**Application No:** Y/55/22/DOC  
**Registered:** 6th May 2022  
**Site Address:** 10 Acre Field Grevatts Lane West Yapton  
**Description of Works:** Approval of details reserved by condition imposed under Y/103/18/PL relating to conditions 8-surface water drainage, 9-discharge flows to watercourses and 10-maintenance and management of surface water drainage.

PLCONDOC (028) 2020

We would not recommend approval until the following points have been addressed;

Drainage Construction Details Proposed Basin Detail Sheet 1 of 2

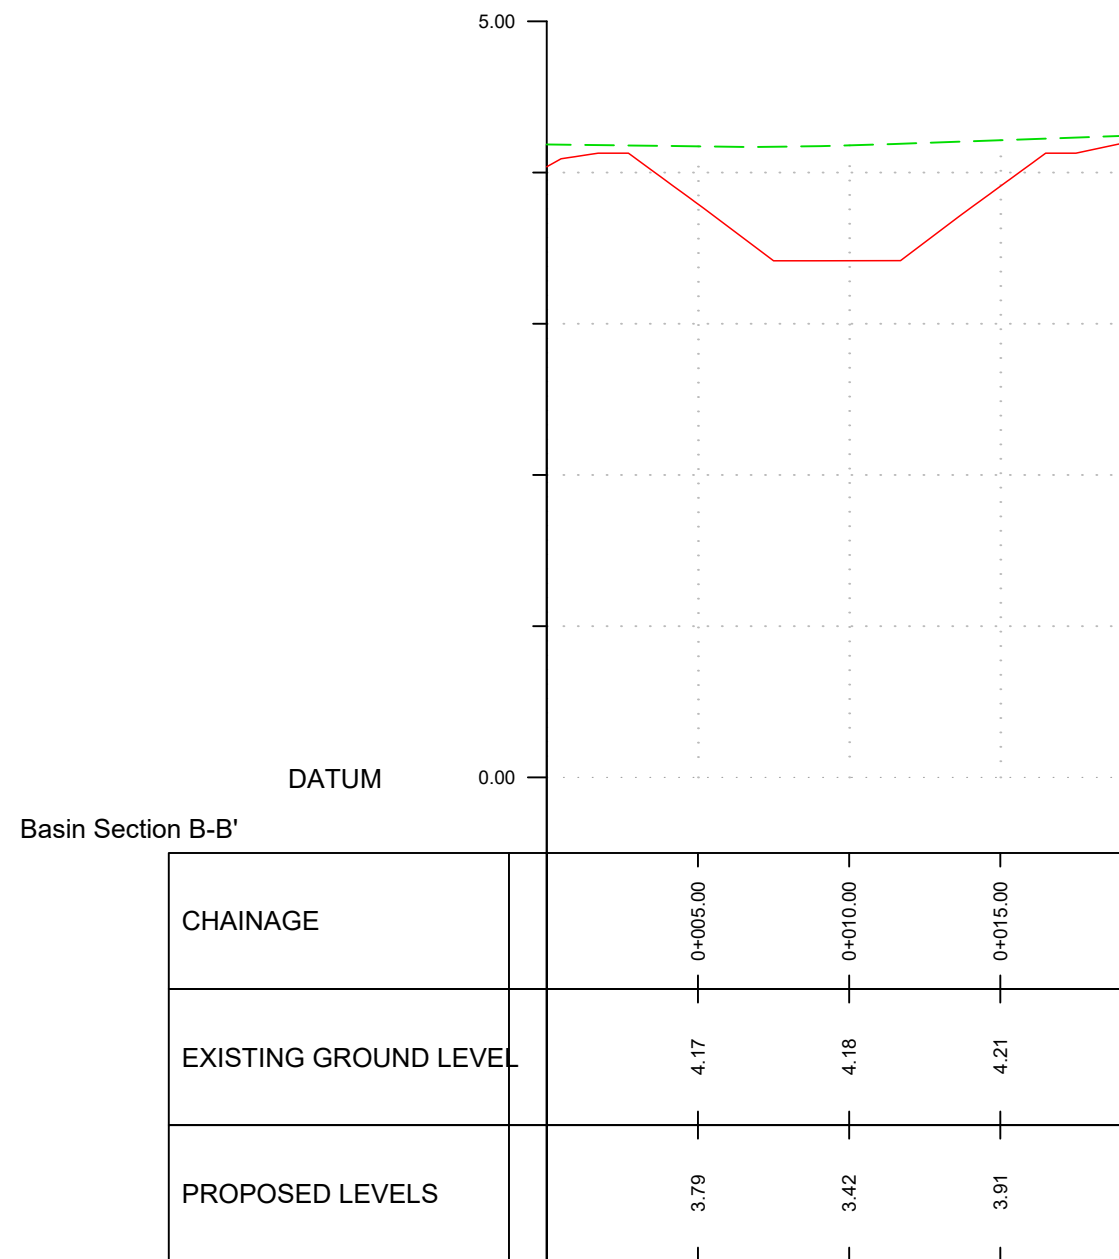
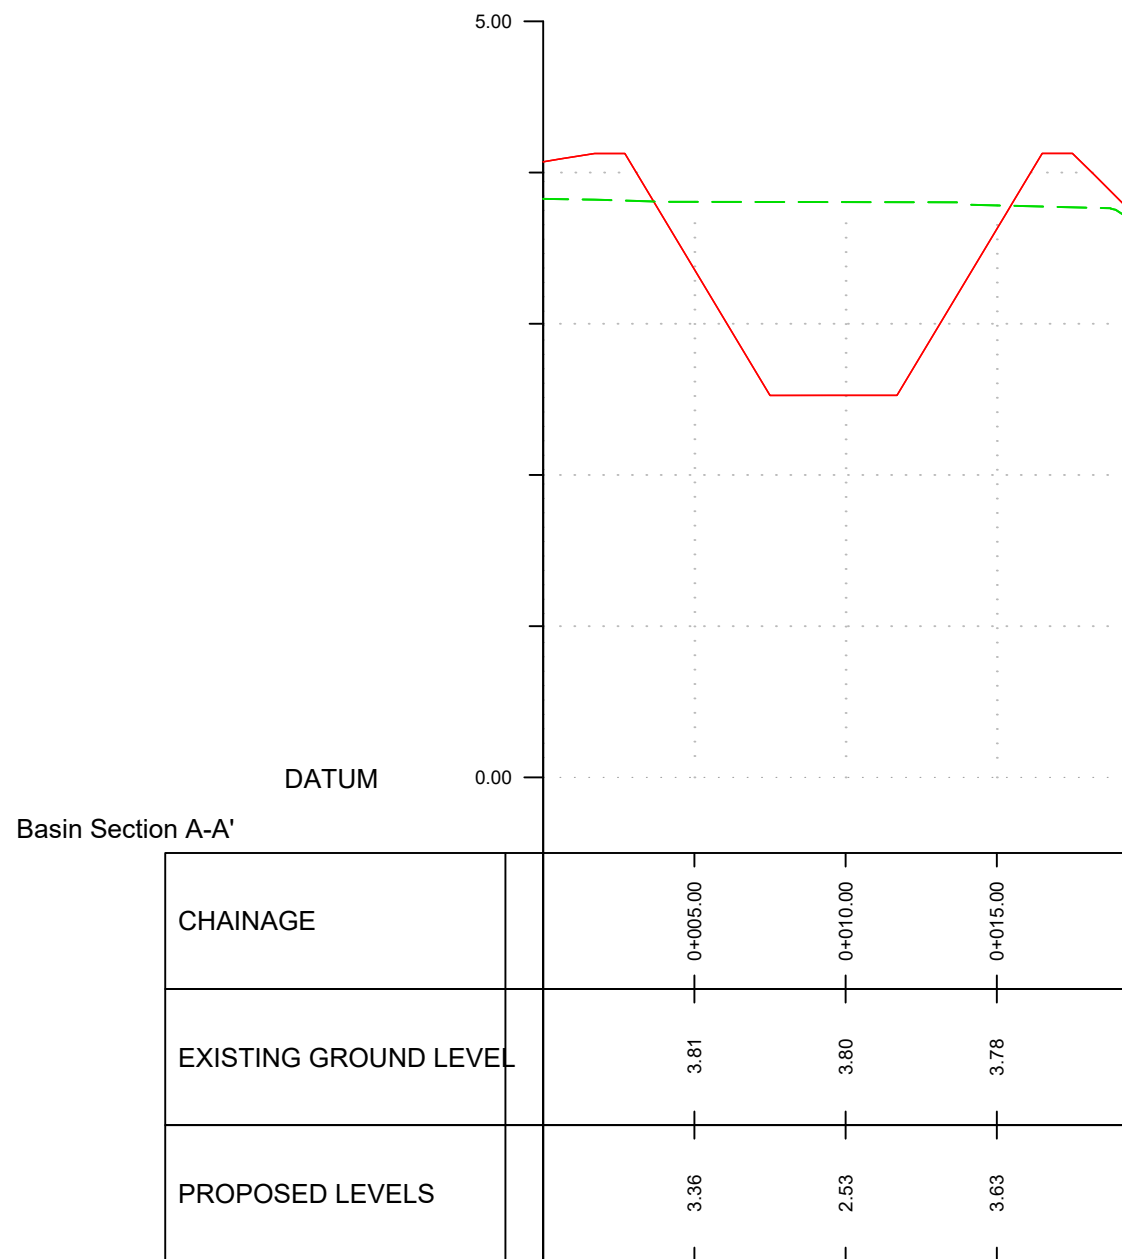
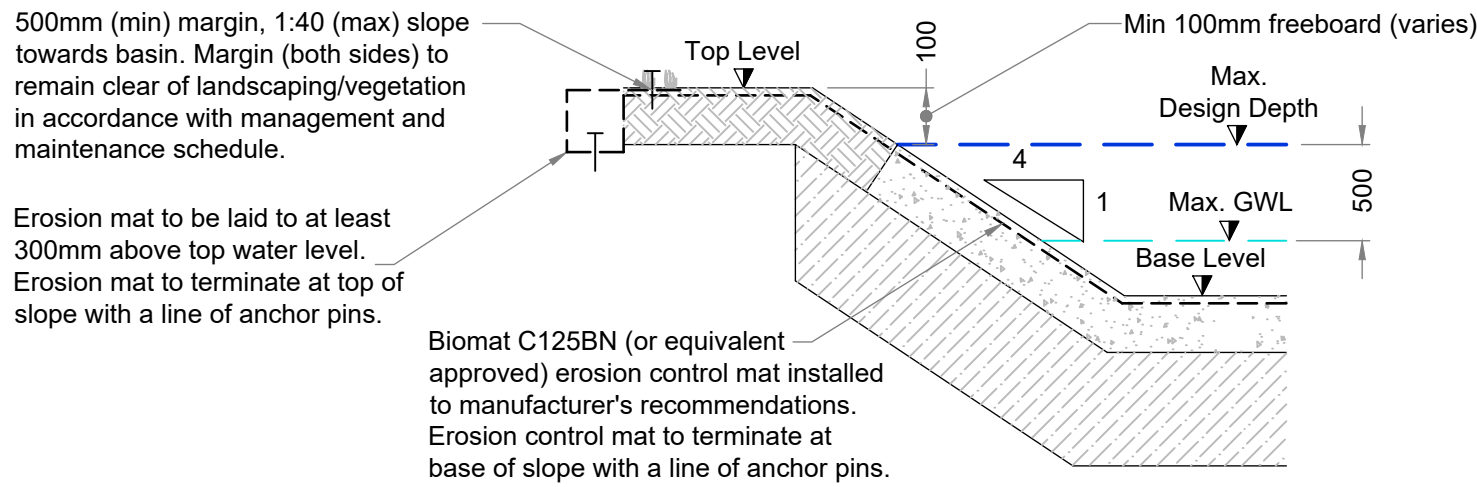
- The Maintenance Plan refers to a sediment forebay “Remove sediment from any forebay”, however, one does not appear to be present on the drainage layout plans, or cross section. The drawing or maintenance plan should be amended so that they are consistent.
